From: Neil Crowther
Sent: 04 February 2019 11:16
To: Planning.Responses
Subject: FW: Discharge of Condition 5 BE/18/17/PL - New Barn Lane, North Bersted

Application correspondence BE/117/18/DOC

Subject: RE: Discharge of Condition 5 BE/18/17/PL - New Barn Lane, North Bersted

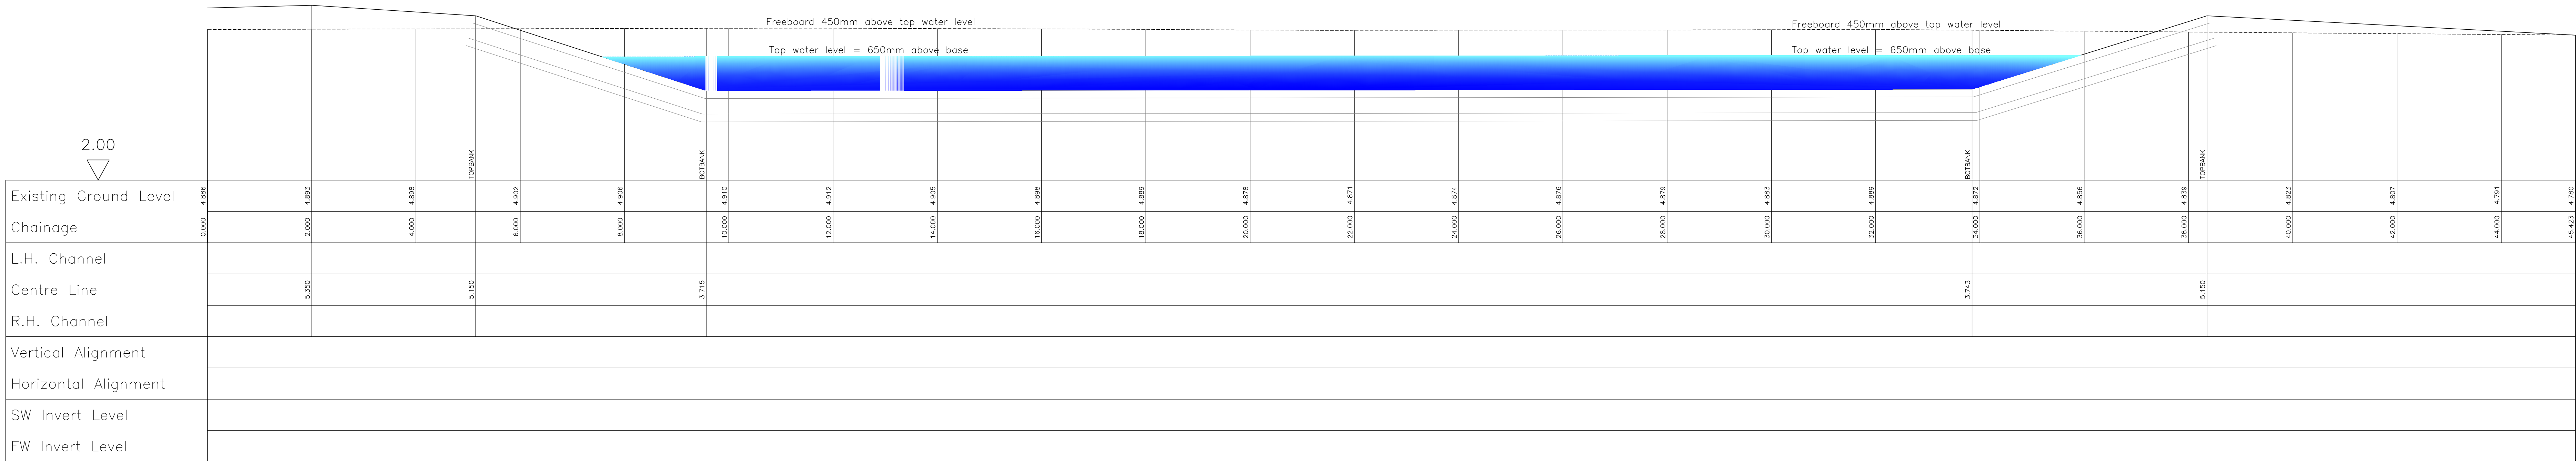
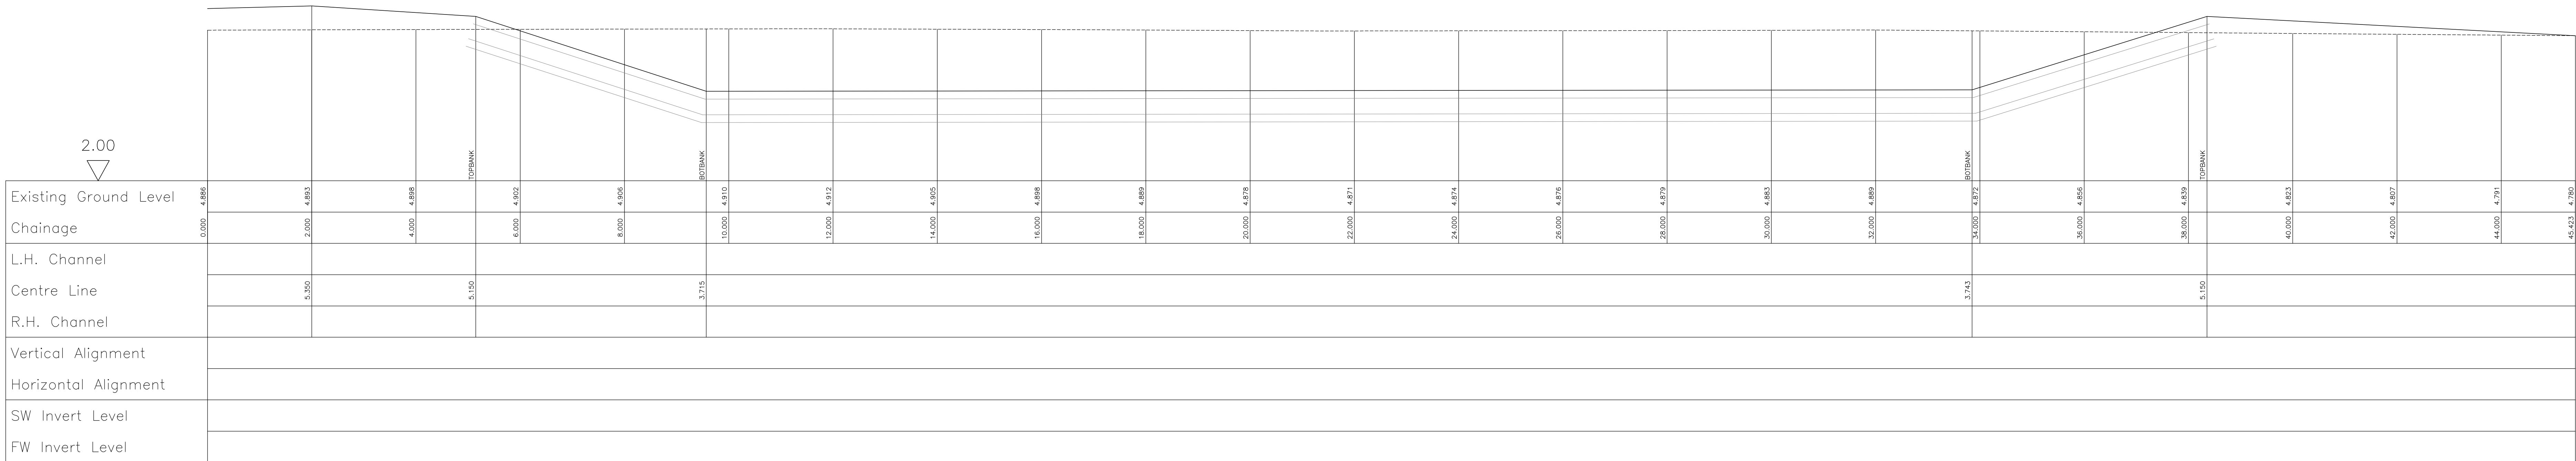
3. Do you have confirmation from southern water that there is adequate capacity?
4. The cross section detail of the pond outfall needs to show the headwall will be graded into the bank. Please update the cross section to ensure turf layer etc. follows the dashed line and meets the top of the headwall.

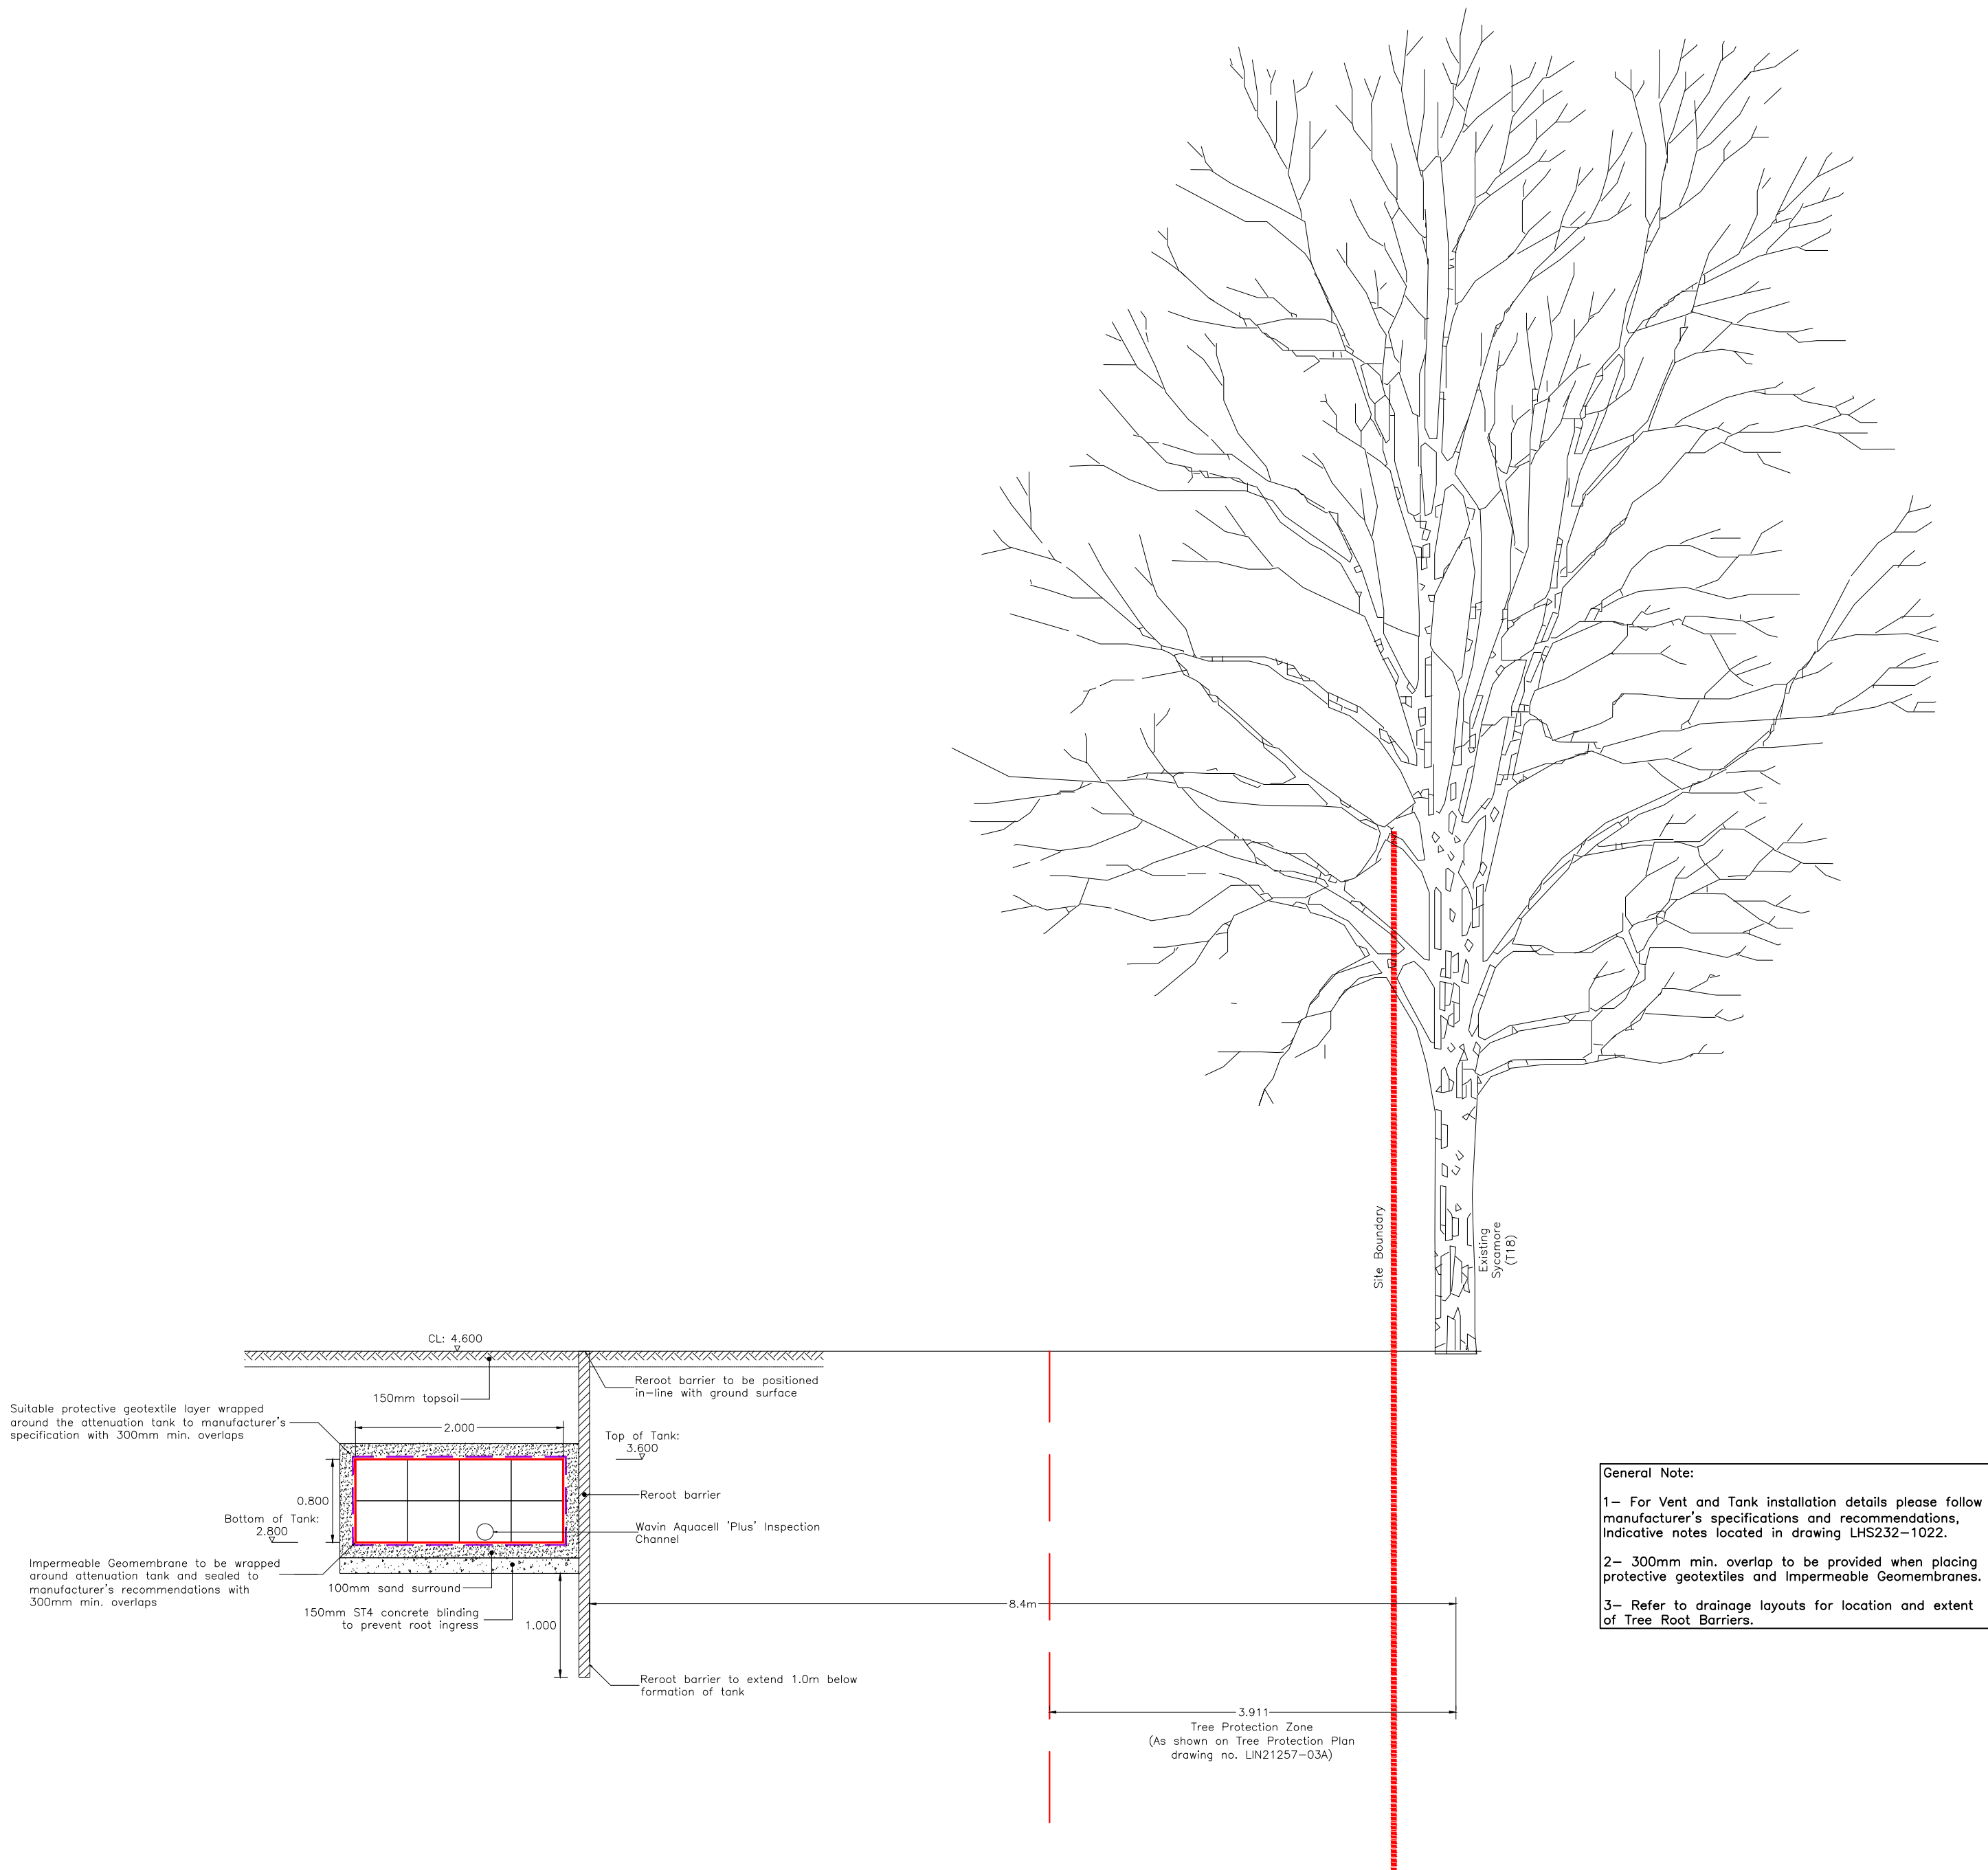
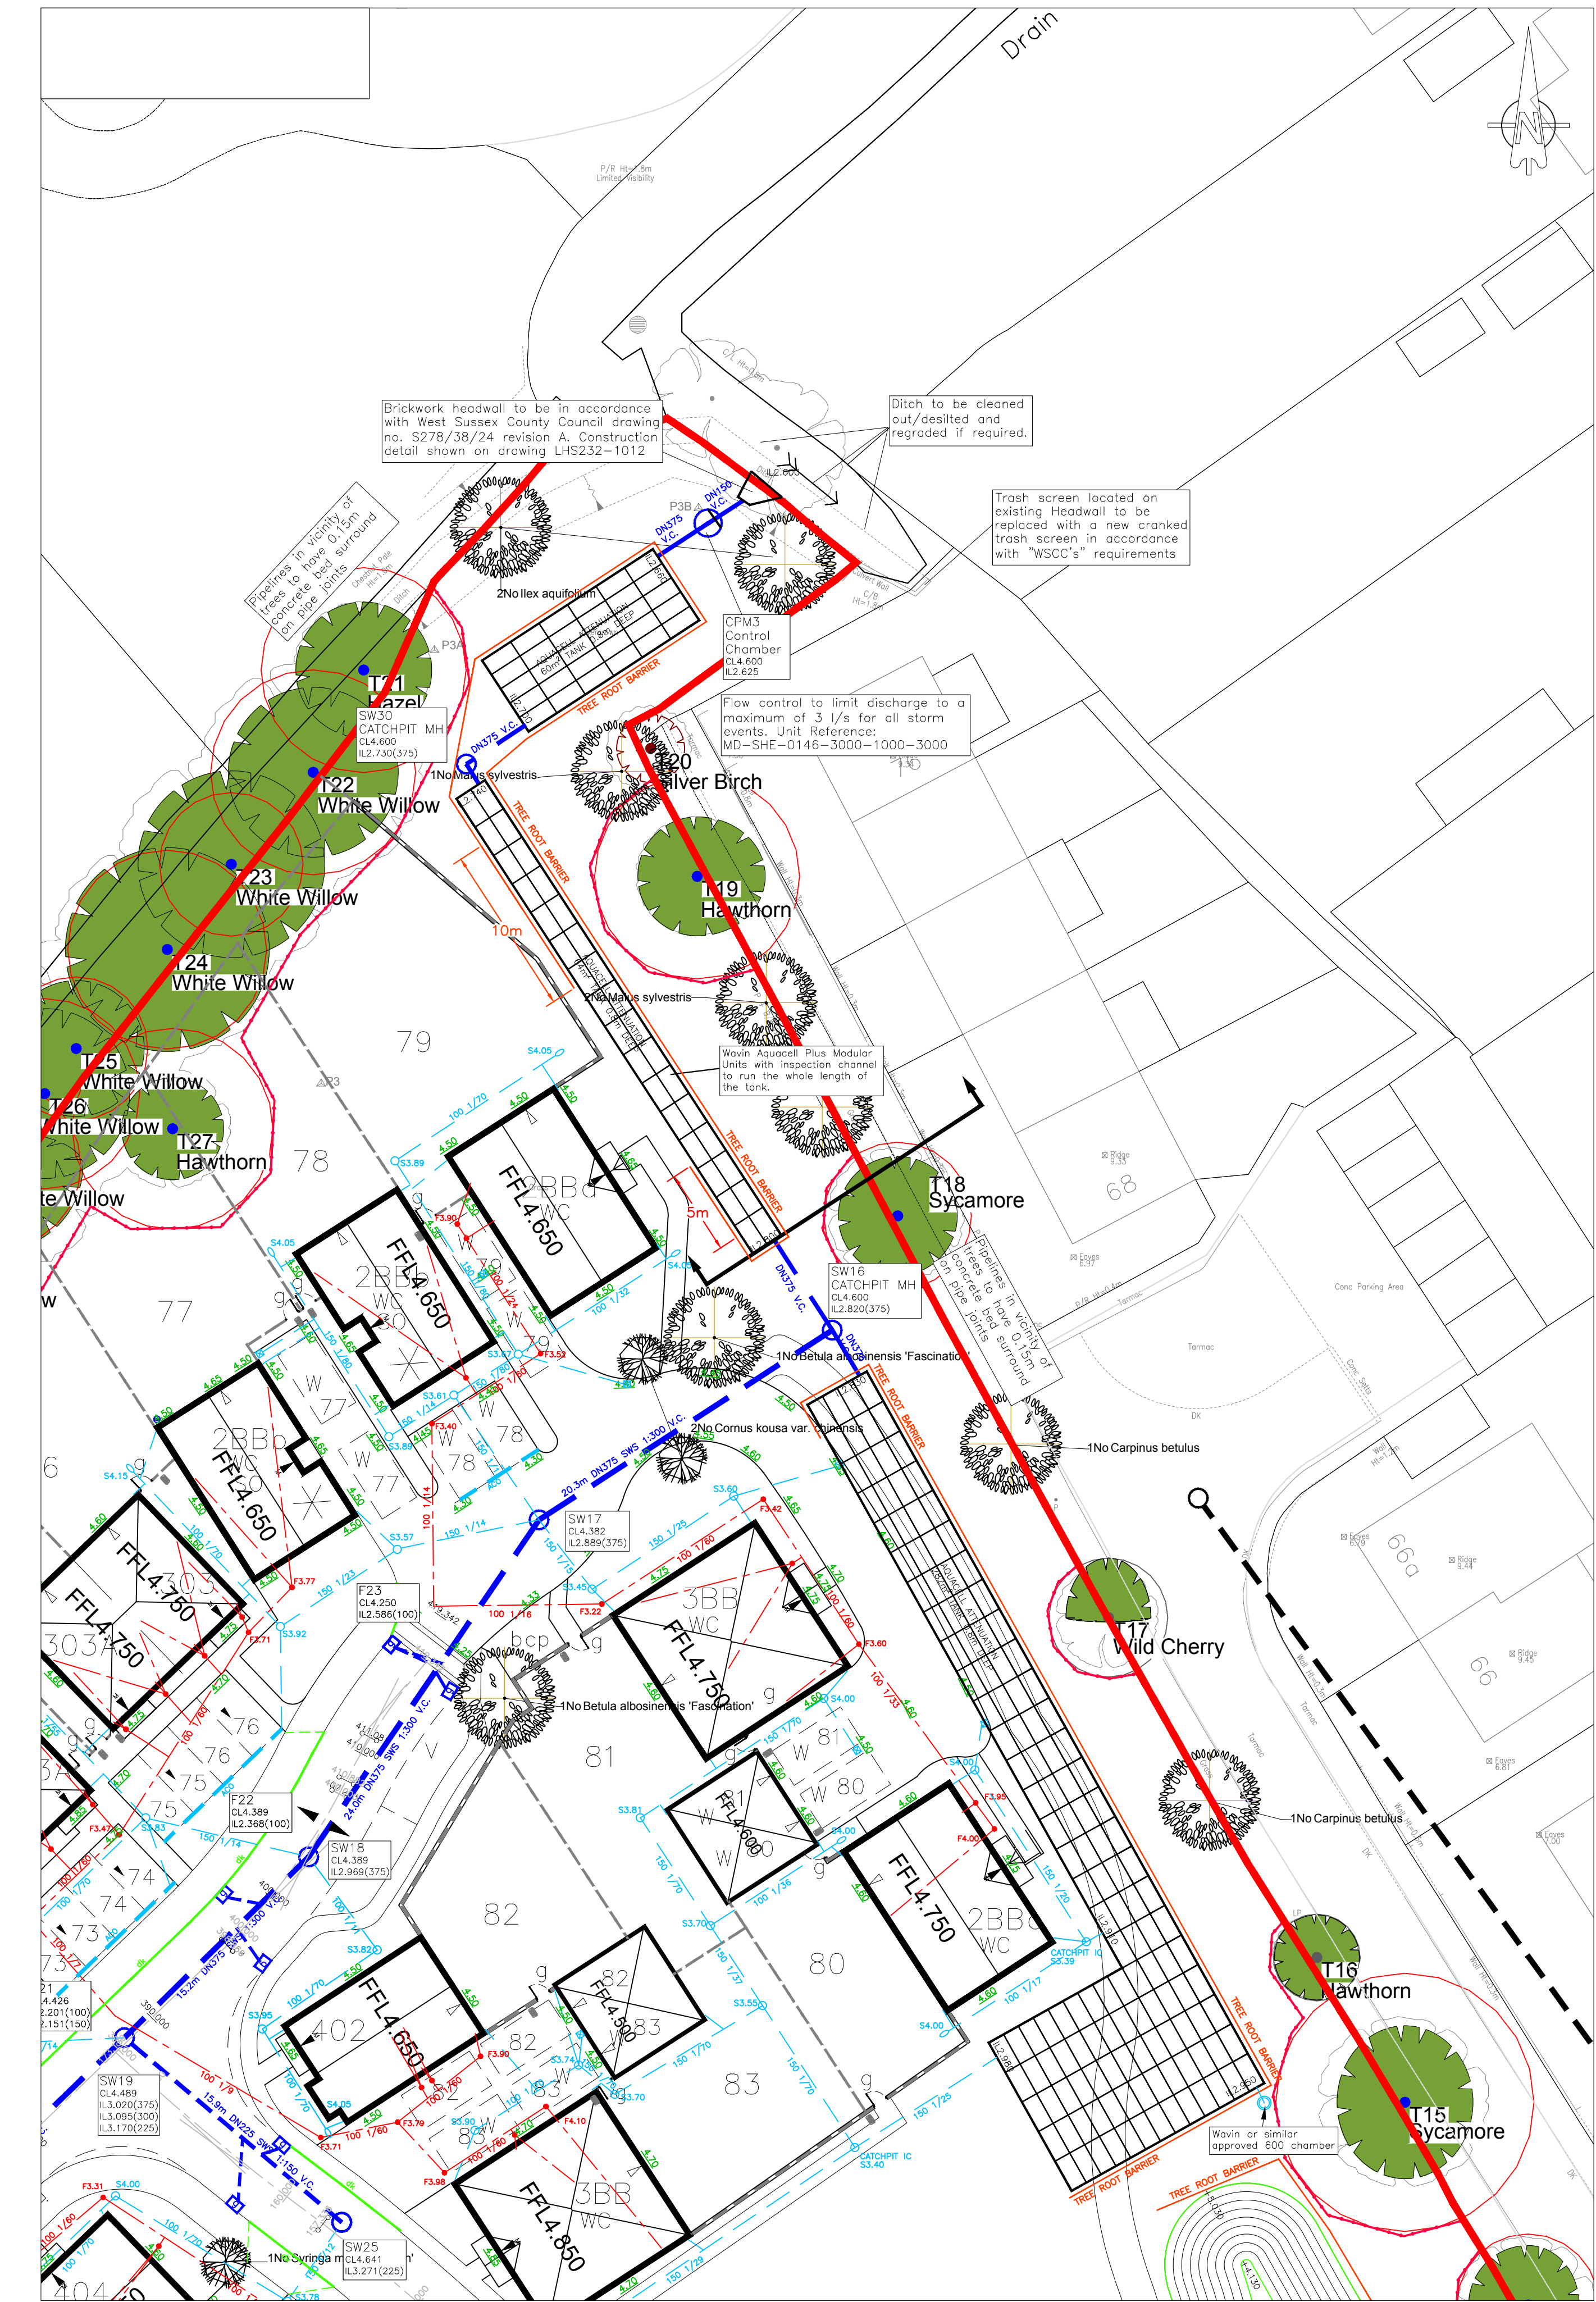
2.75mm of binding concrete is insufficient. Please provide 150mm of ST4 concrete.
MJA Response—Noted, detail revised as instructed; Okay
